Our Ref: R/2024/1
File No: 2024/208397
Your Ref: SSD 59006709

Alexandria Health Centre Detailed Design – SSD 59006709 - Advice on EIS

SSD 59006709 seeks consent for the construction of a 7 storey mental health hospital and medical centre, with 77 car parking spaces, site works including a new laneway, public domain works and landscaping.

C300

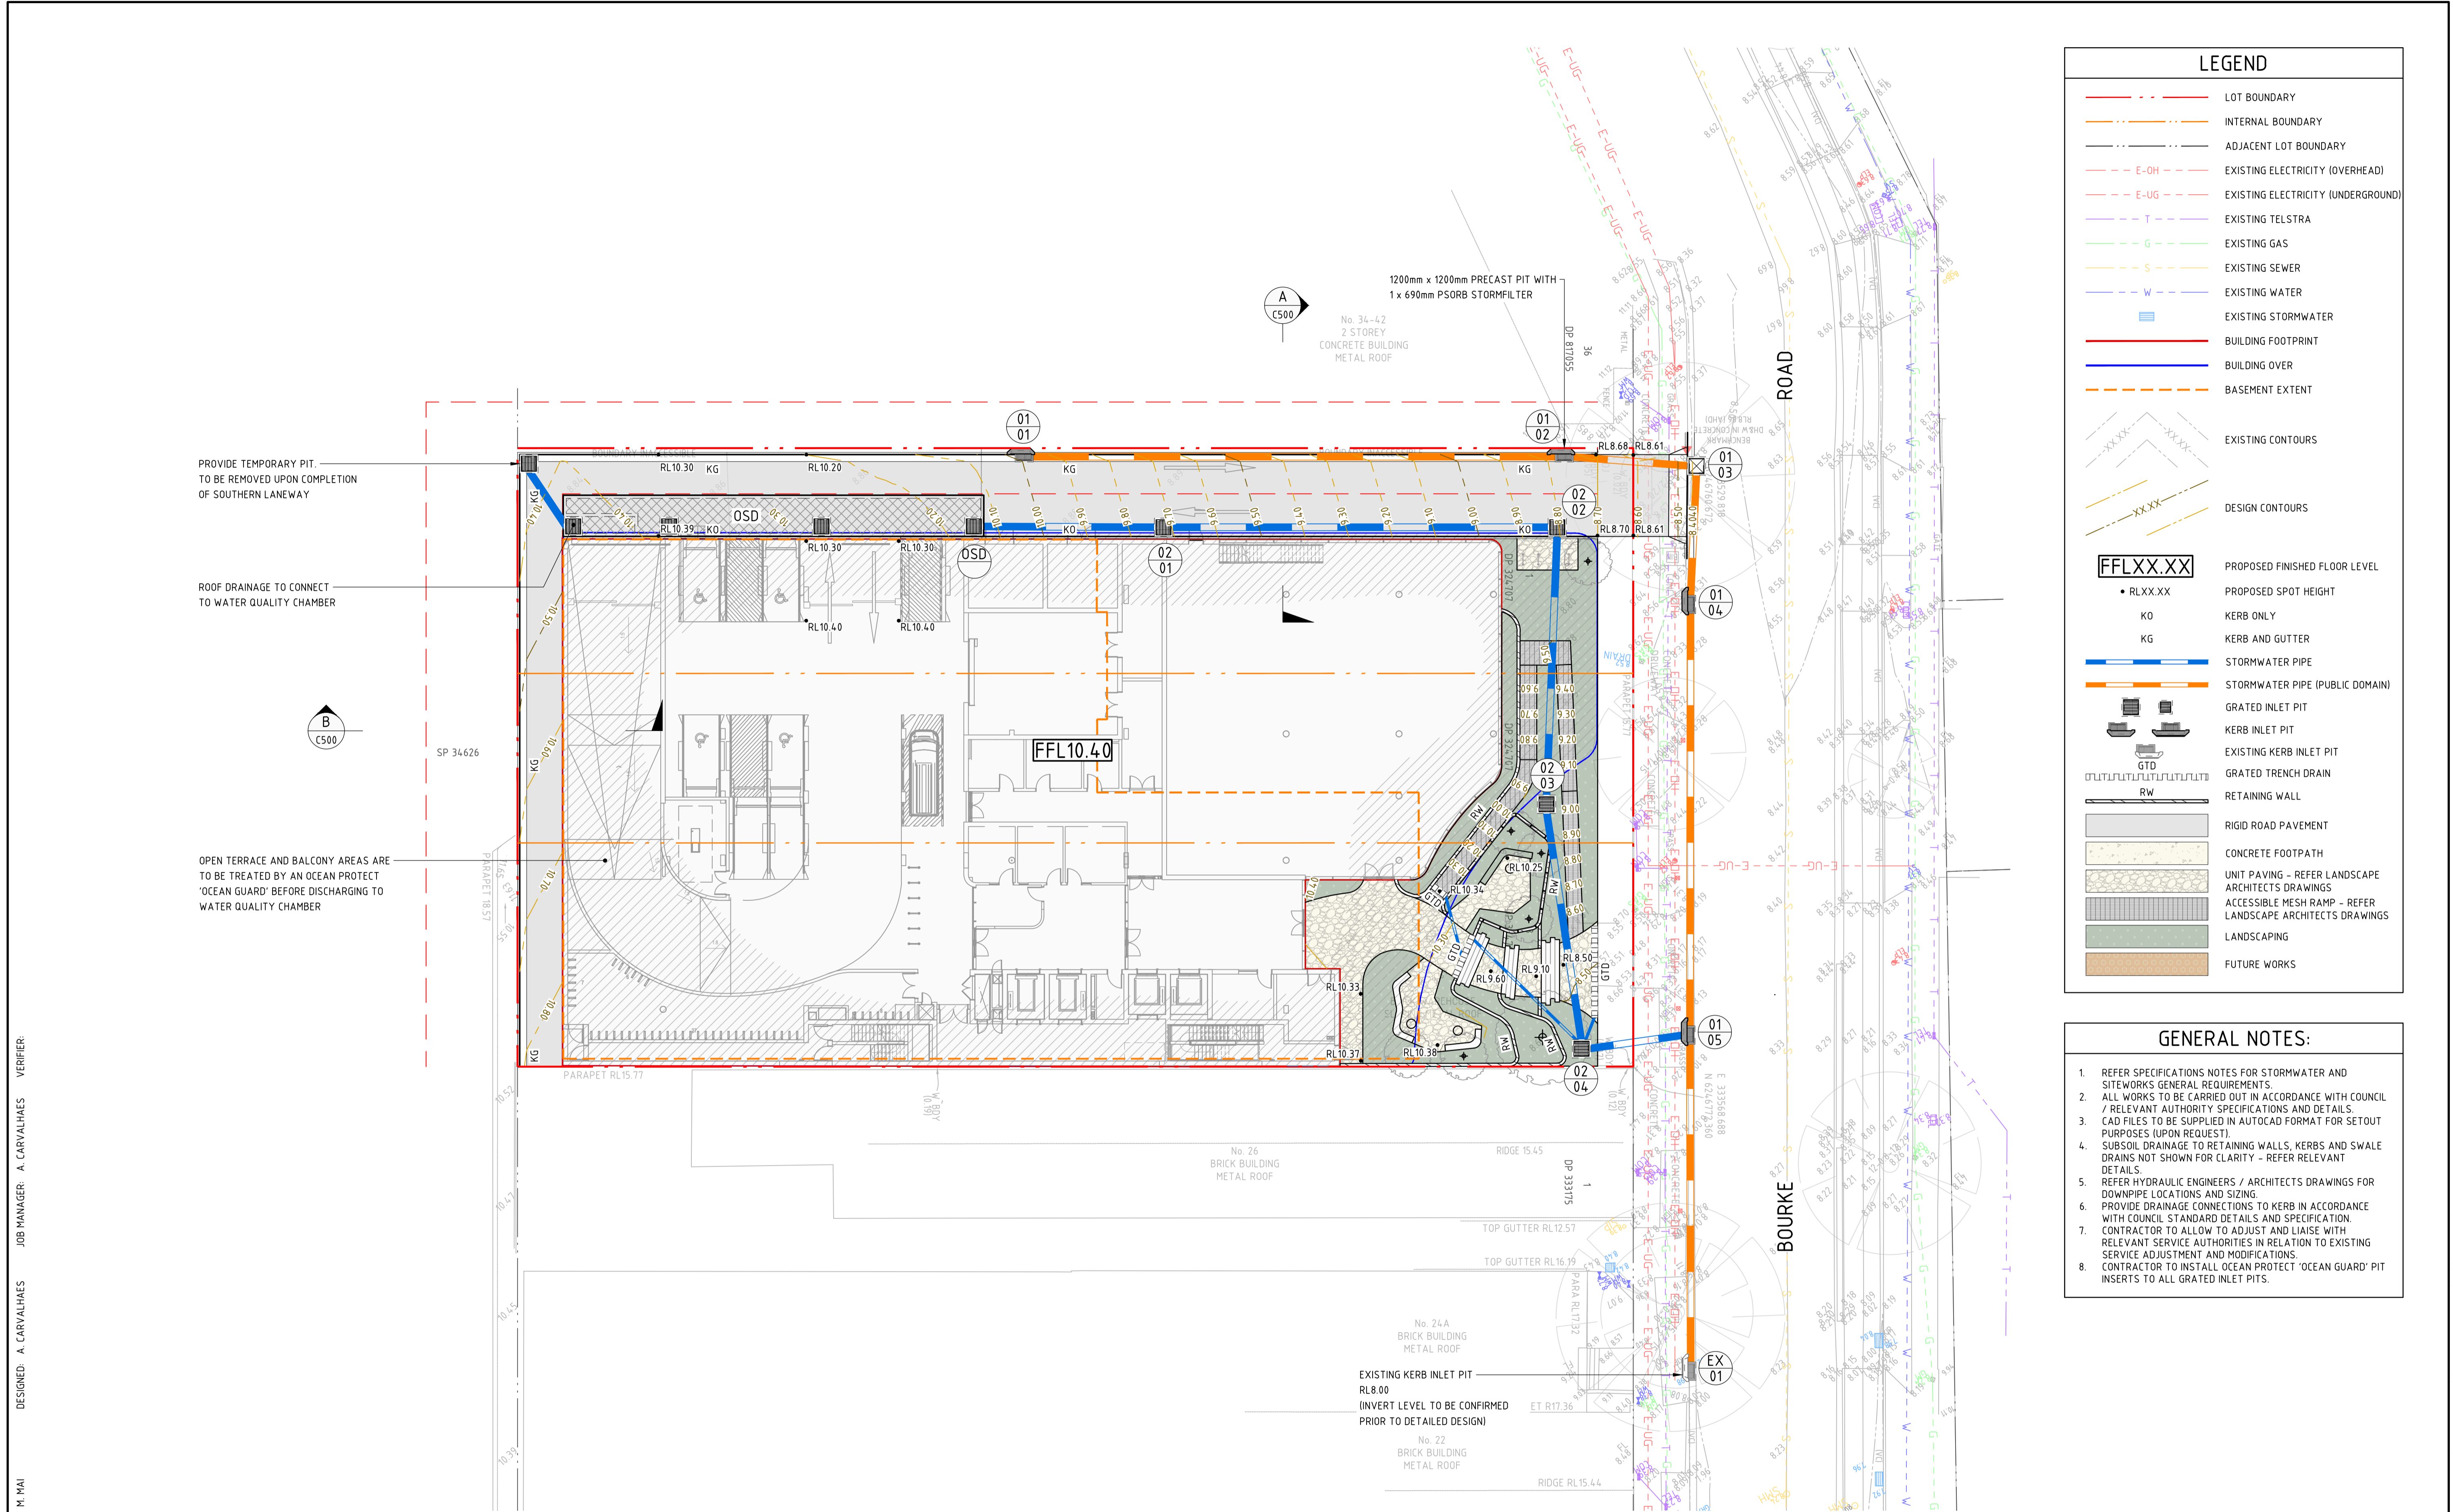
The Civil Design plans depict proposed OSD being located within the temporary lane, with access interfering with the driveway for basement and ground-level carpark. It is recommended that the access pits be relocated away from the driveway, and wholly within the new property boundaries.

Additionally, the proposal shows stormwater drainage pits (KIPs) and pipes along the eastern end of the laneway which in future will possibly be in the middle of the laneway in the ultimate development scenario. The design should consider the ultimate development scenario, how stormwater drainage in the laneway will change and how drainage in the laneway connecting O'Riordan Street and Ashmore Connector will be managed as a result, including any capacity issues downstream.

**Drawing Title**  
**EAST ELEVATION**  
**Drawing Status**  
**STAGE 2 SSSA**

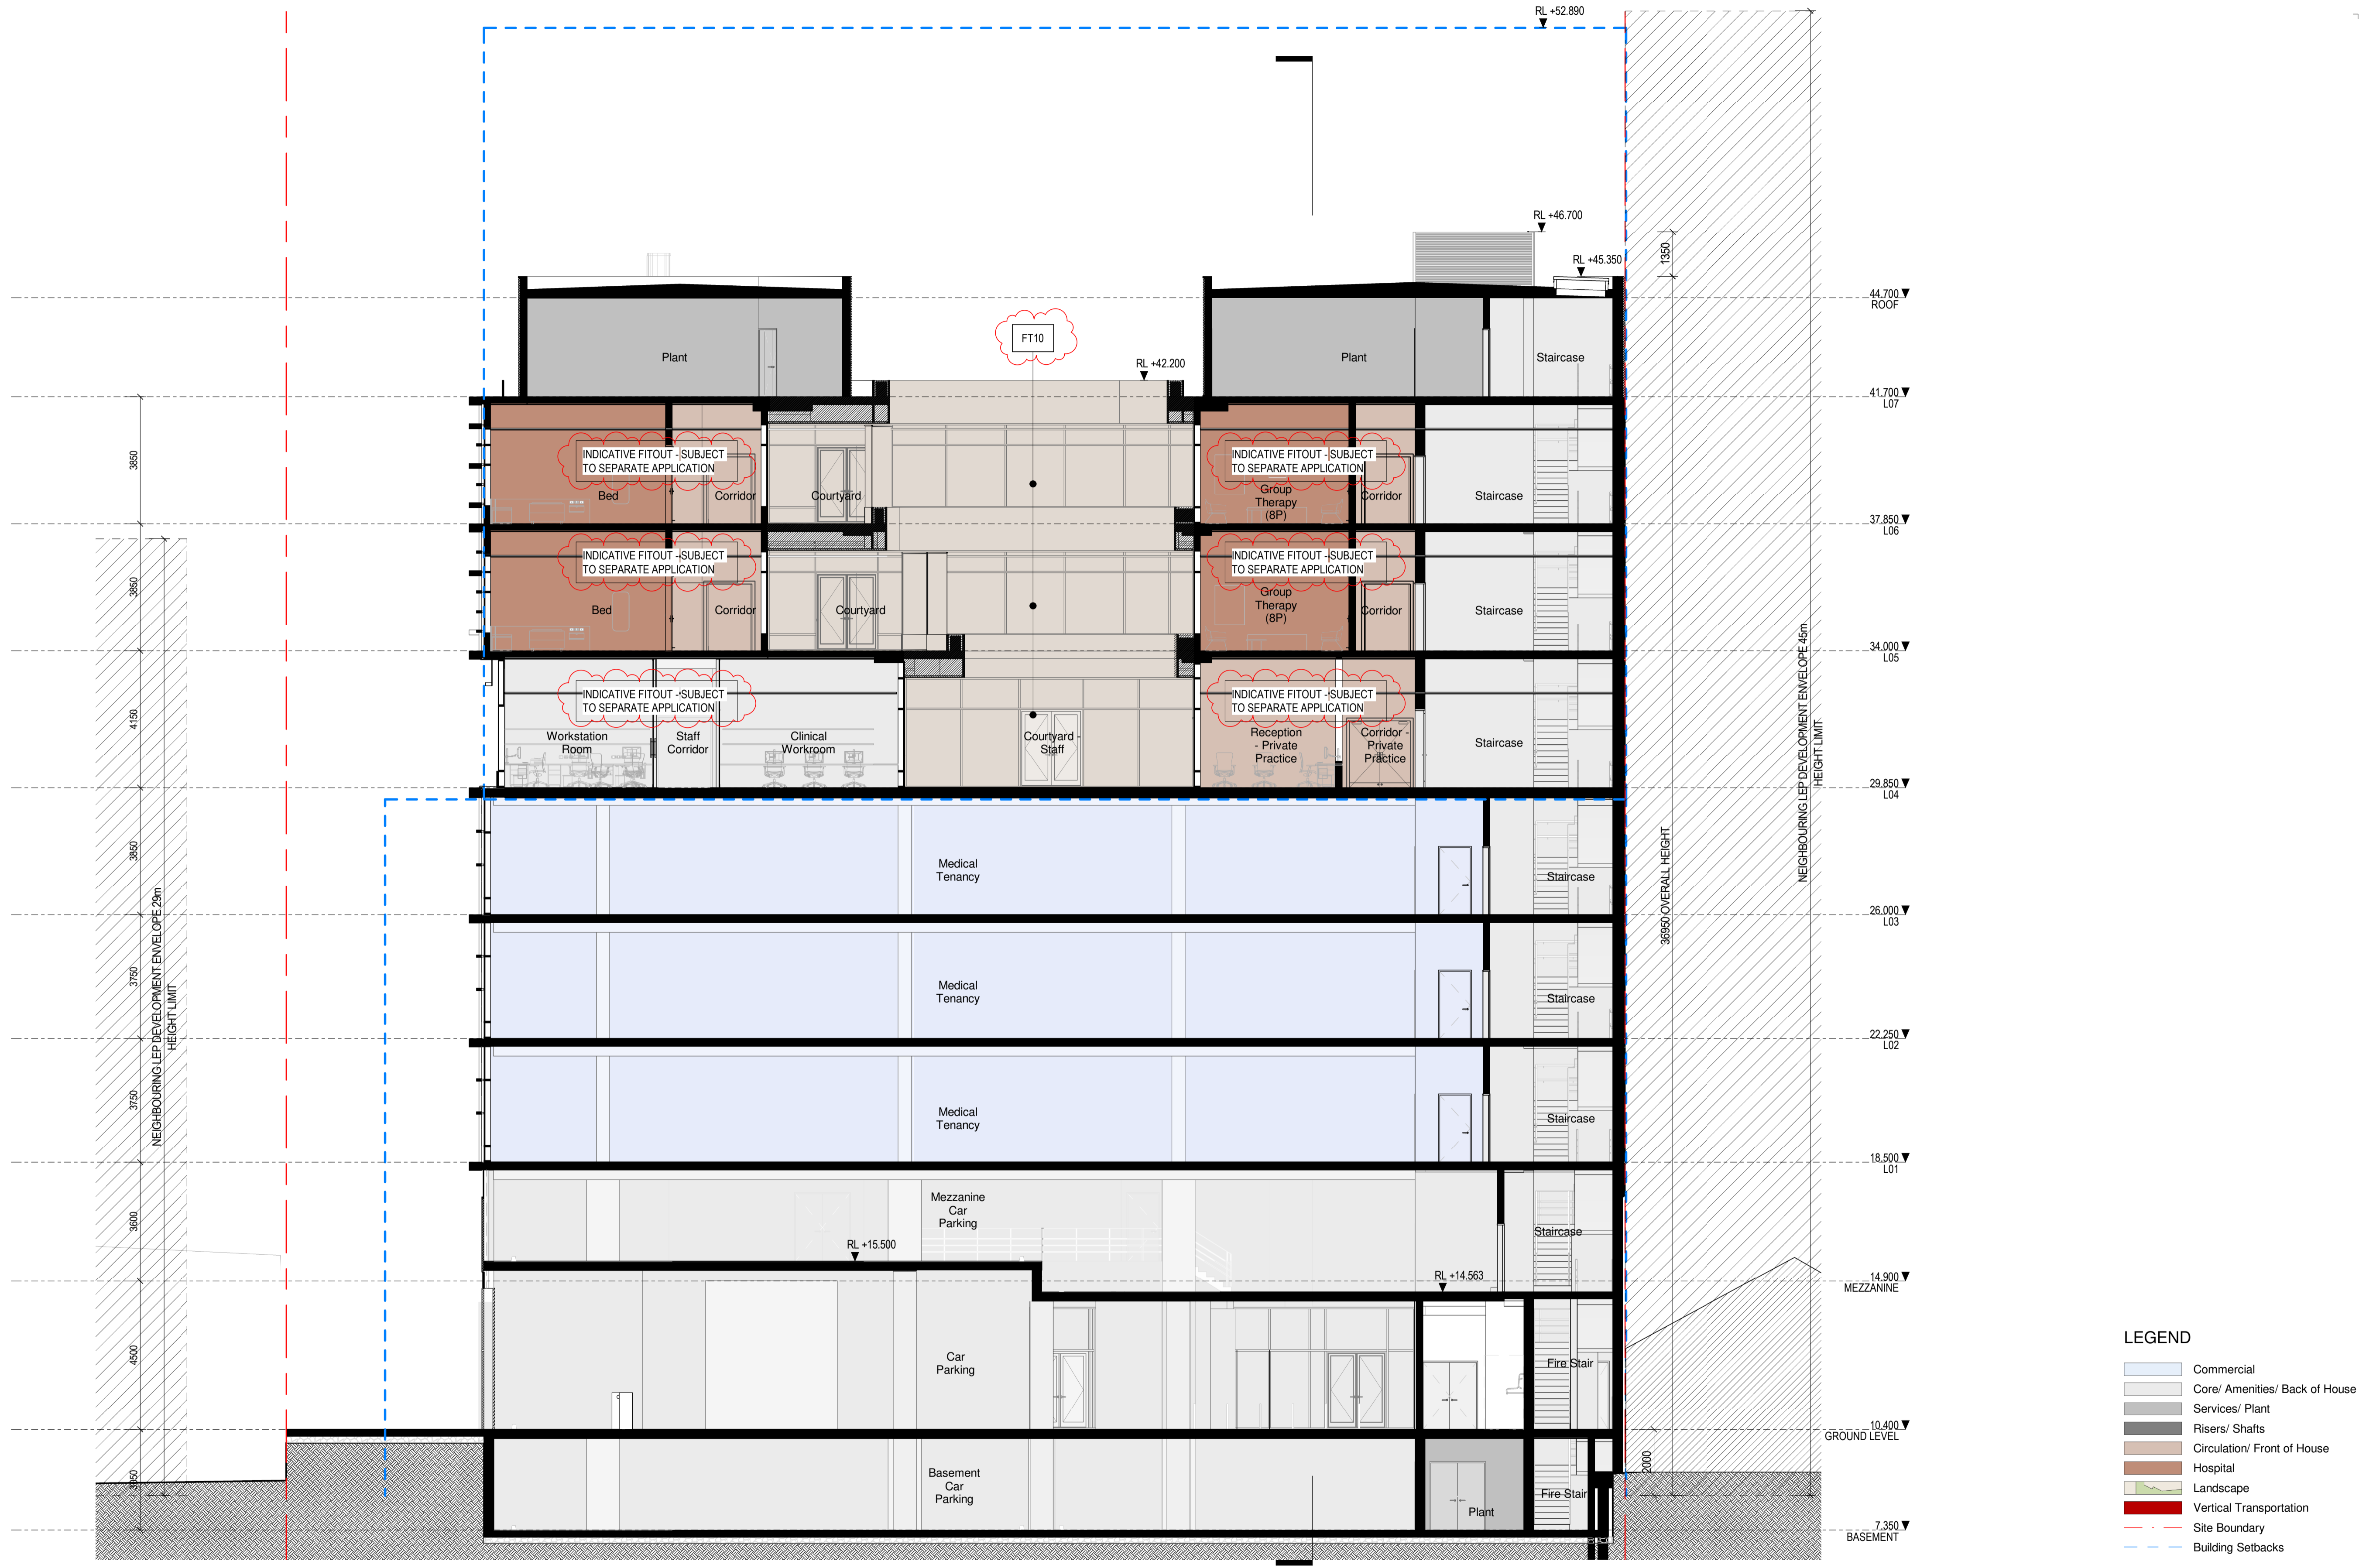
- The eastern elevation is to be further articulated to provide visual interest, noting the proposed setback and redevelopment of 26 Bourke Road, Alexandria as part of D/2023/691 which is currently under assessment by the City. As per the Design Jury comments, consideration is to be given to artwork in this location.
- All external materials must be fully described and keyed on elevations, sections and the material and finishes schedule. The details must include specific product information where relevant, including manufacturer's detail, material type, finish and colour. There should be no reference to 'similar to'.
